**From:** Thomas Whitfield <thomas@georgiangroup.org.uk>  
**Sent:** 24 September 2025 08:01  
**To:** DC Admin  
**Cc:** Conservation Design  
**Subject:** Case 2025/92388 - Red House Museum, 281 Oxford Road, Gomersal

Thank you for notifying The Georgian Group of application 2025/92388 for a scheme of works to convert The Red House Museum, 281 Oxford Road, Gomersal from 3no. residential units. The Group registers no objection in principle to the conversion however we raise the following concerns with the proposed scheme of works.

The application is for a scheme of internal and external works to convert the house to form 2no. residential units and the barn to 1no. residential unit.

Drawing Title
**Barn
Elevations as Proposed**

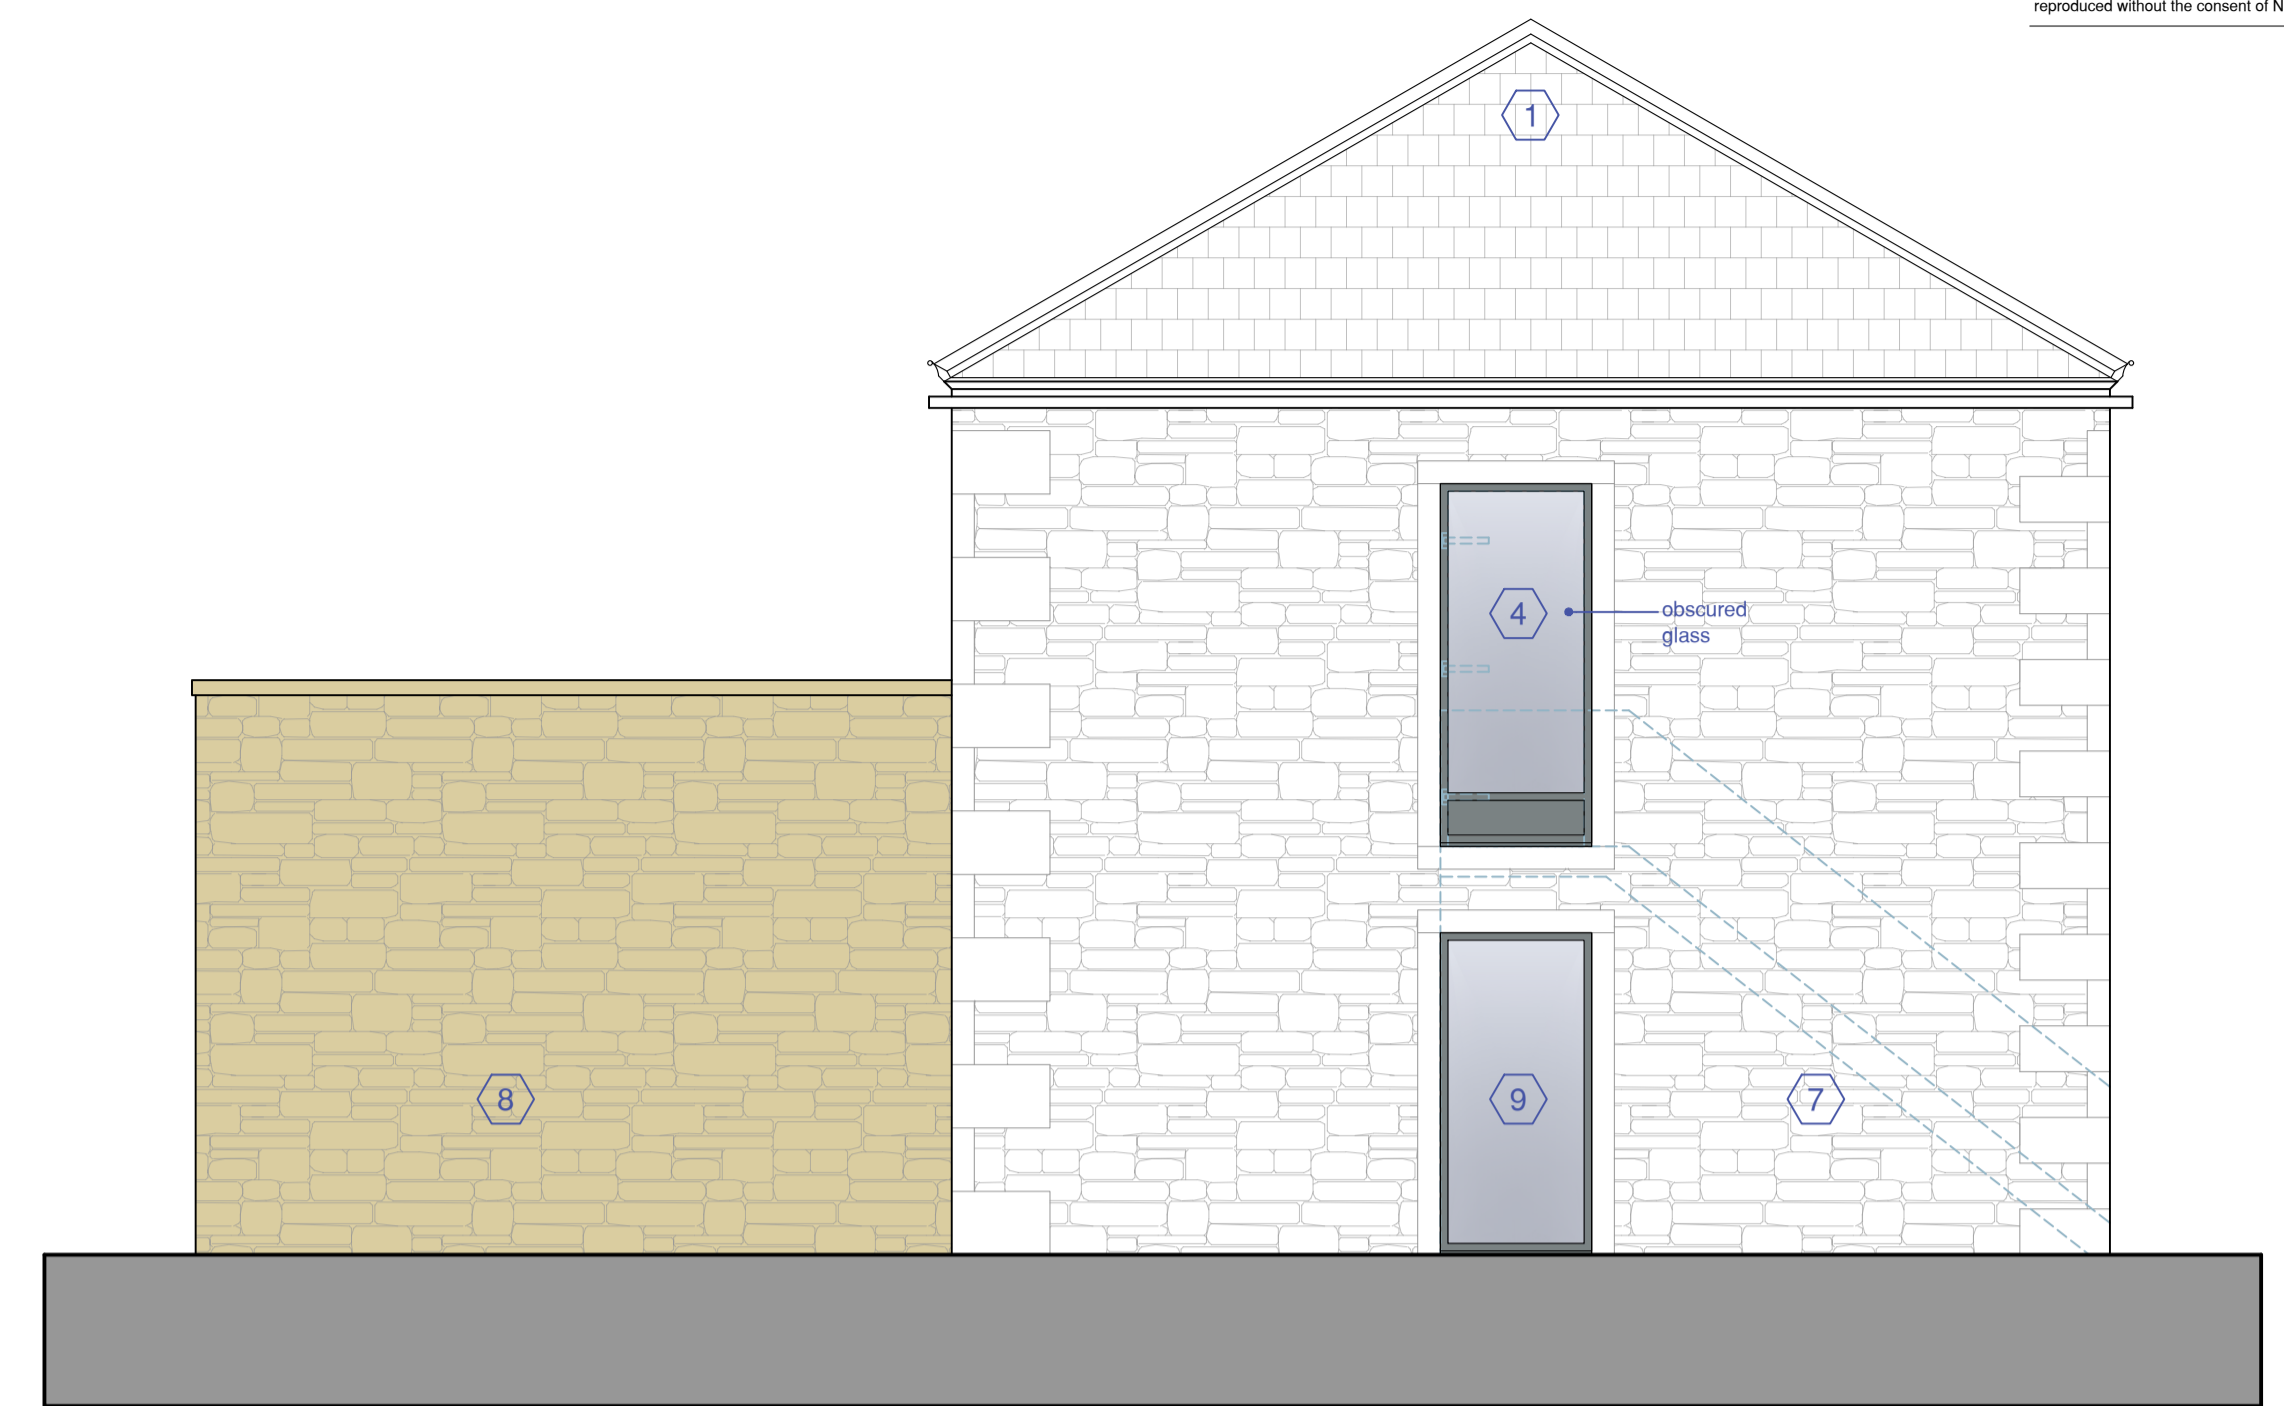
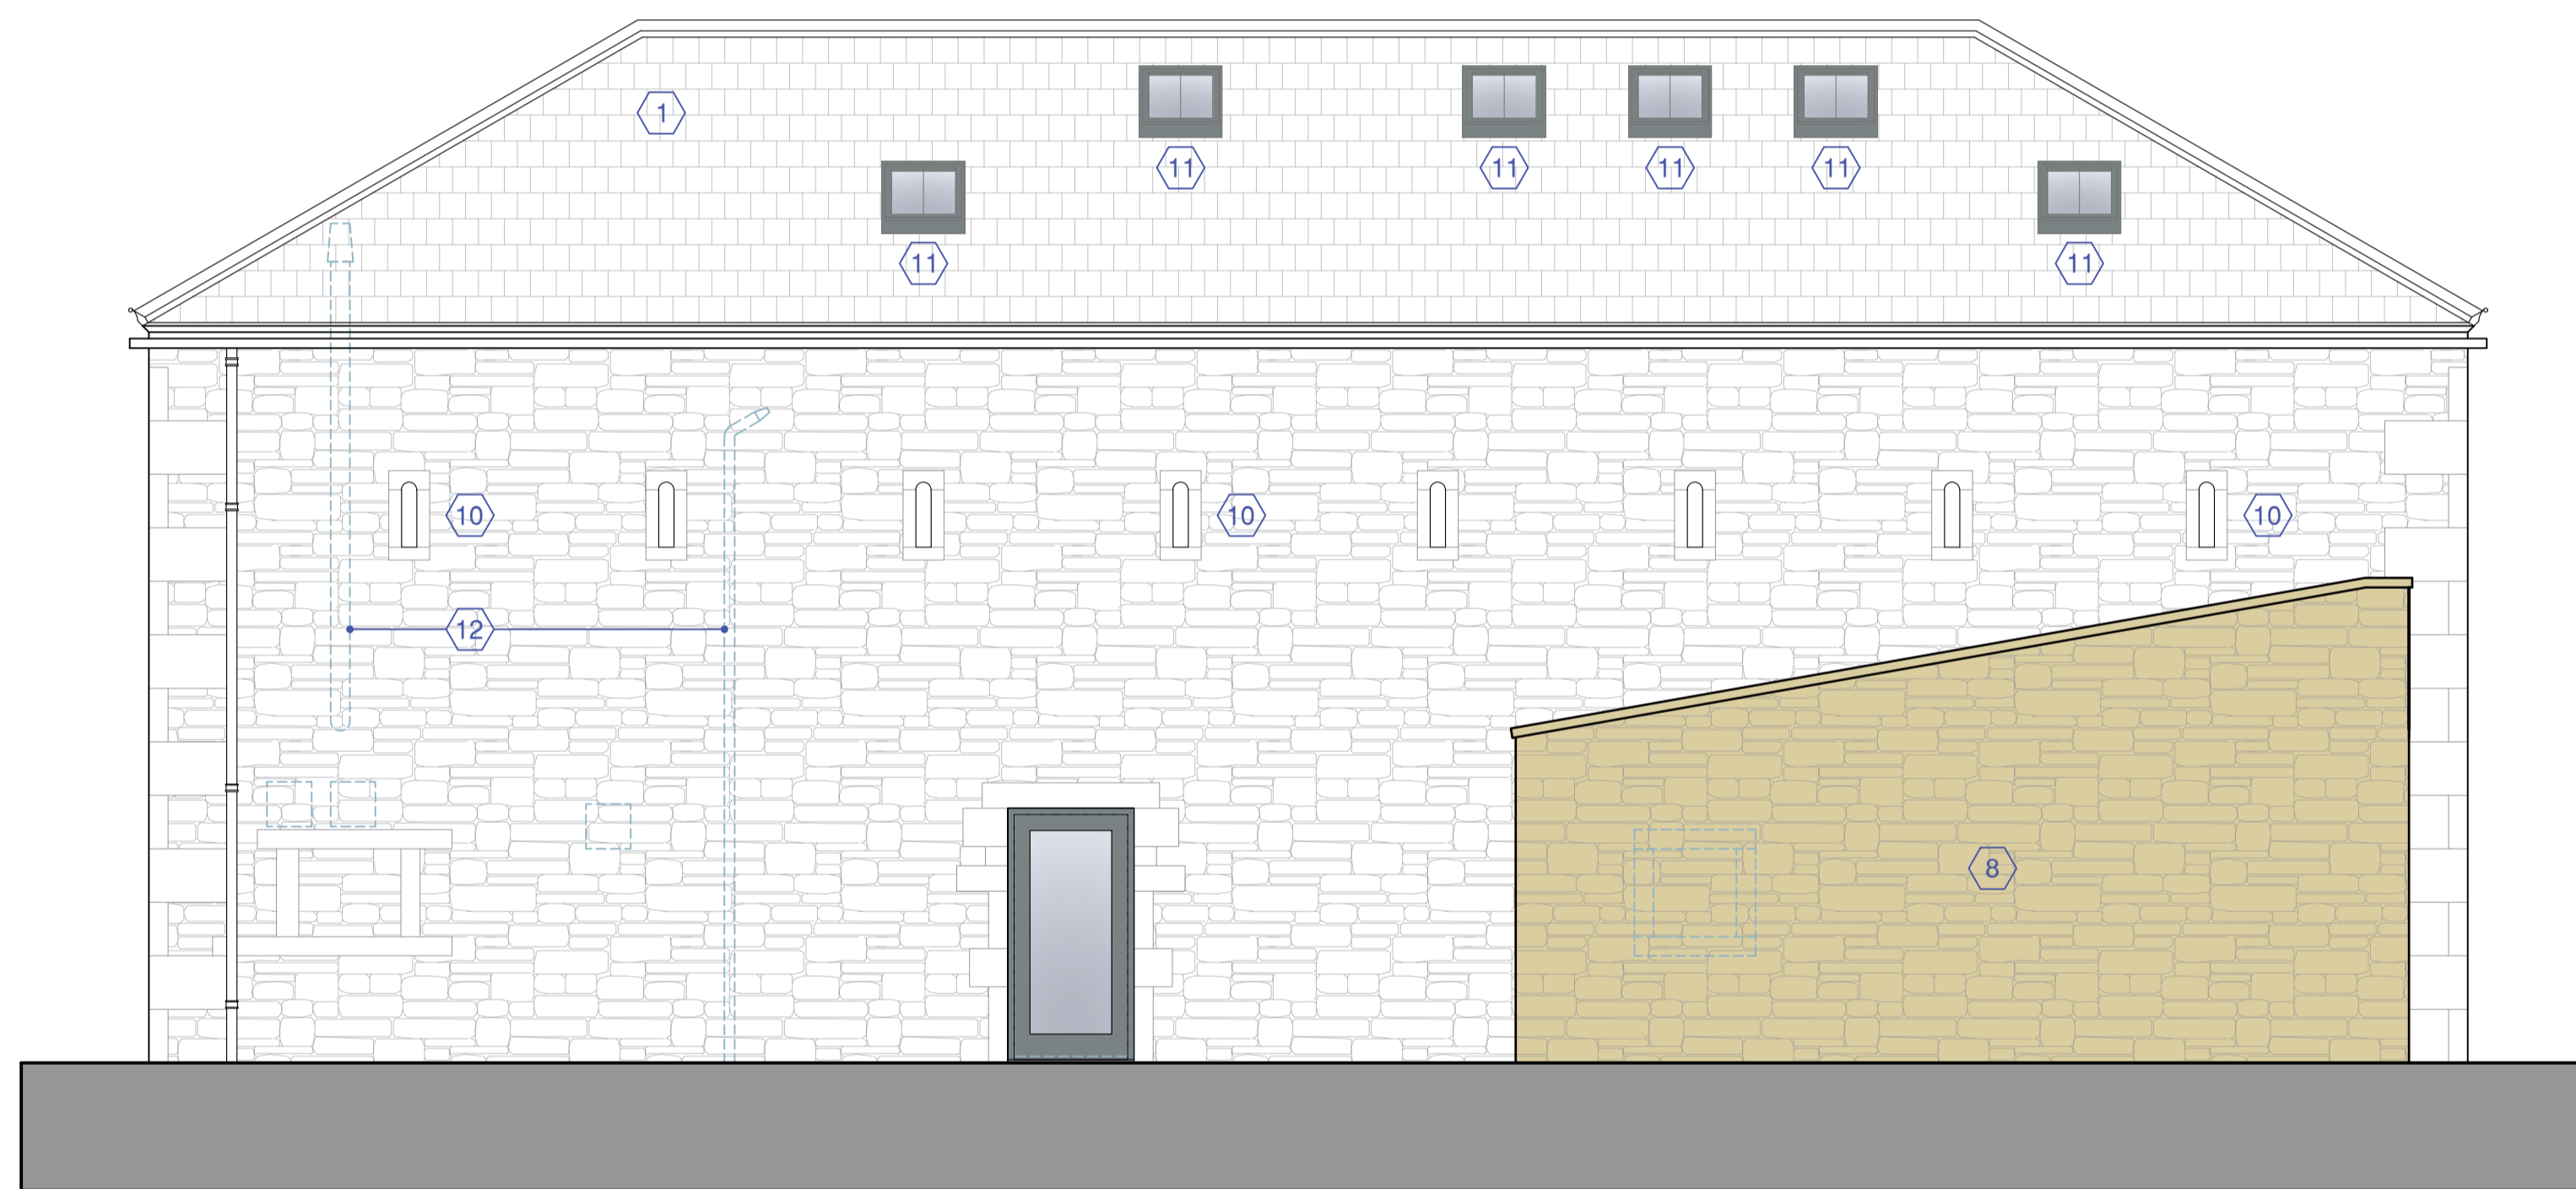
The Group immediately registers concerns that the proposed window replacements are to be in a significantly different materials palette and pane arrangement. The Group acknowledges that the existing windows are non-historic units, and we raise no objection to their being replaced, however we strongly recommend that this should be like for like in materials and design.

We advise that the window arrangement to the barn contributes strongly to its historic character and architectural significance, and they offer strong legibility of the historic significance of the Red House complex more generally as being involved in the textiles industry. The ocular windows and central mullioned window provide a strong and clear indication of the historic use of the building as an unusual historic combination of barn and cloth inspection/finishing space.

Changing the materials and design of the windows would consequently cause significant harm to the building's historic character and special architectural and historic significance, denuding its evidential, aesthetic and group values. We advise that this is contrary to the requirements of the NPPF paragraph 212. We furthermore advise that it is neither clearly nor convincingly justified under the terms of paragraph 213. We accordingly also highlight the requirements of section 72(1) of the Planning (Listed Buildings and Conservation Areas) Act 1990 that LPAs also have a duty to pay special attention to the desirability of preserving or enhancing the character or appearance of conservation areas.

We recommend that any replacement windows should be like for like to the existing in terms of materials and design.

The Group additionally recommends that timber doors should be retained or reinstated (either functional or fixed) to help preserve the historic character of the barn.

We advise that the number and the irregular spacing and positioning of the proposed rooflights is assertive and visually intrusive impacting negatively on the historic character of the barn.

We advise that the rear elevation of the barn is a well ordered and austere elevation with the slot-breathers/windows spaced with rigid regularity giving the elevation a highly ordered and regular character. The proposed rooflights by contrast are irregularly spaced and positioned conflicting with the historic regularity of the elevation.

The number and arrangement proposed for the rooflights is, by our understanding, due to the need to provide natural light to the proposed bathroom facilities and internal corridors. We advise that this could be best mitigated by reconsidering the internal layout to allow bathrooms to be better lit existing windows/slot breathers, reducing the need for so many rooflights

We therefore recommend that alternative internal arrangements are explored to reduce the need for so many and such awkwardly arranged rooflights.
